File No: NTH08/01399/02
Your Ref: MP08_0167_MOD2

**S.75W Major Project Modification of MP08_0167 for Residential Subdivision (Malbec SWR P/L)
Lot 36 DP 1214499, Belle O'Connor Street, South West Rocks**

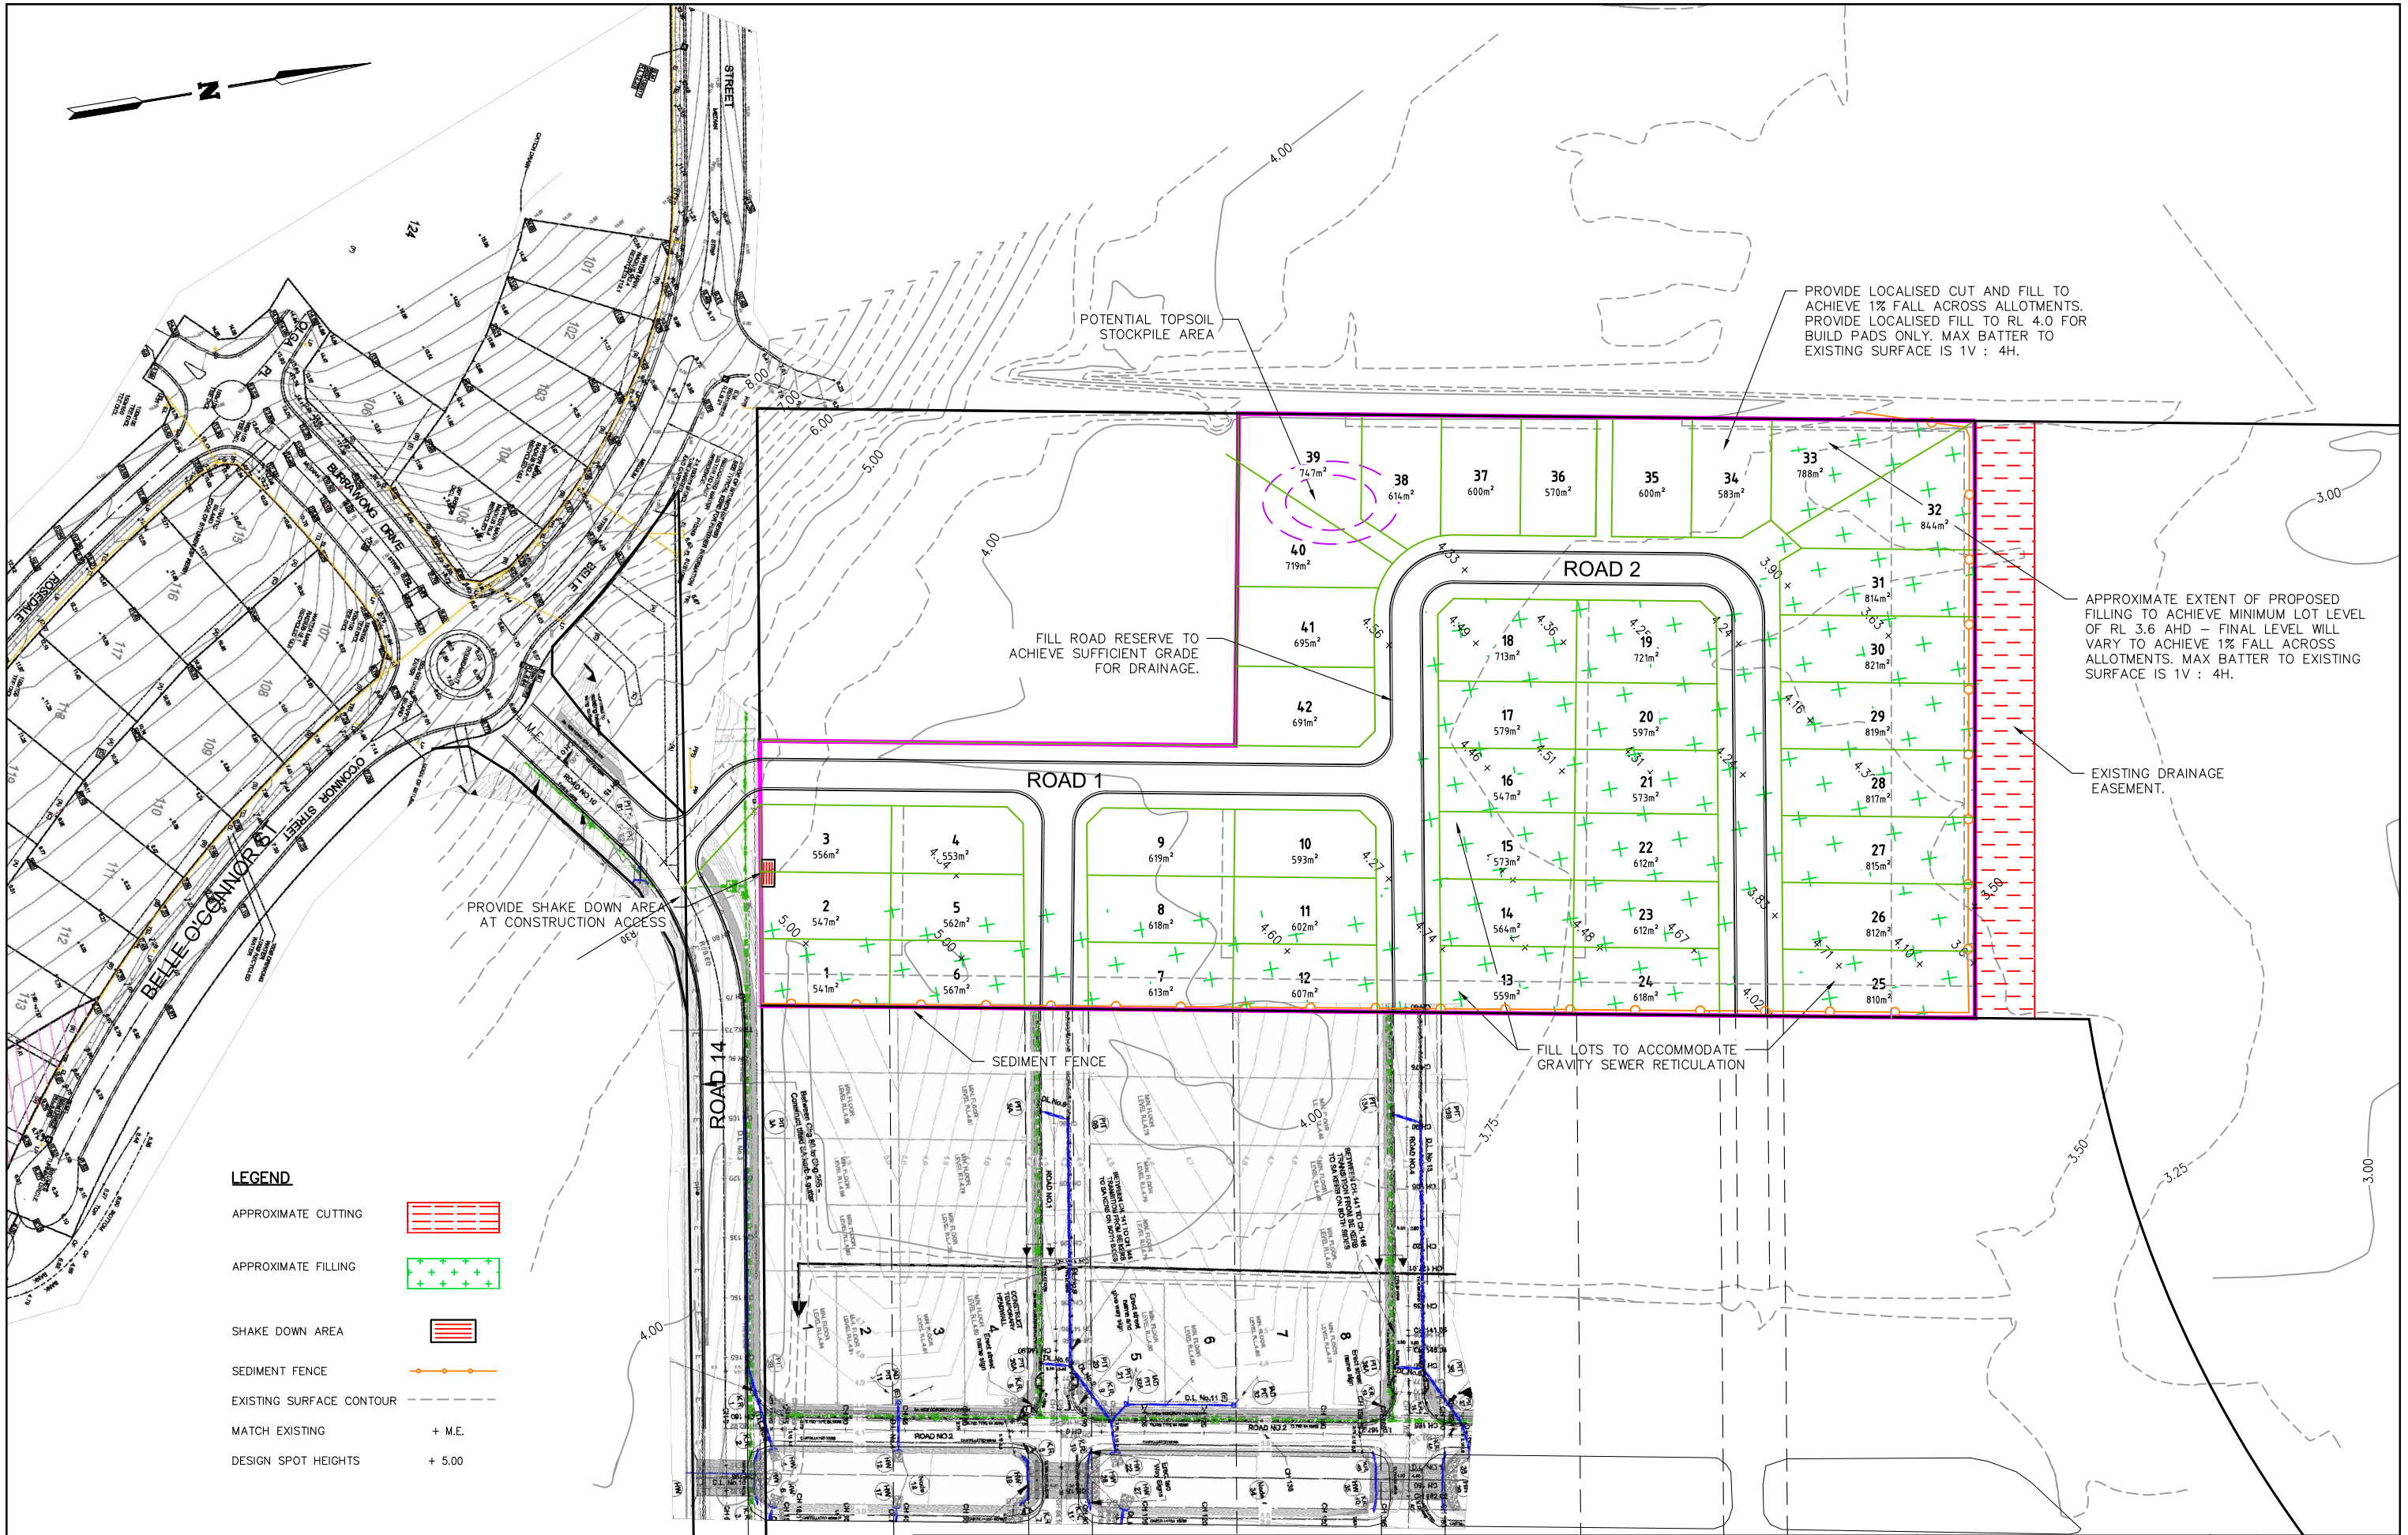
1. The proposed increase in the total number of allotments will generate a subsequent increase in daily and peak hour traffic movements that has not been addressed in the application. The Consent Authority should consult with Council, as the relevant Road Authority, to ensure that proposed amendments to the future road network remain consistent with Council's wider network strategy.
2. The proposed layout and any new intersection should be appropriately located and designed to safely accommodate vehicle, pedestrian and bicycle movements generated by the proposed development.
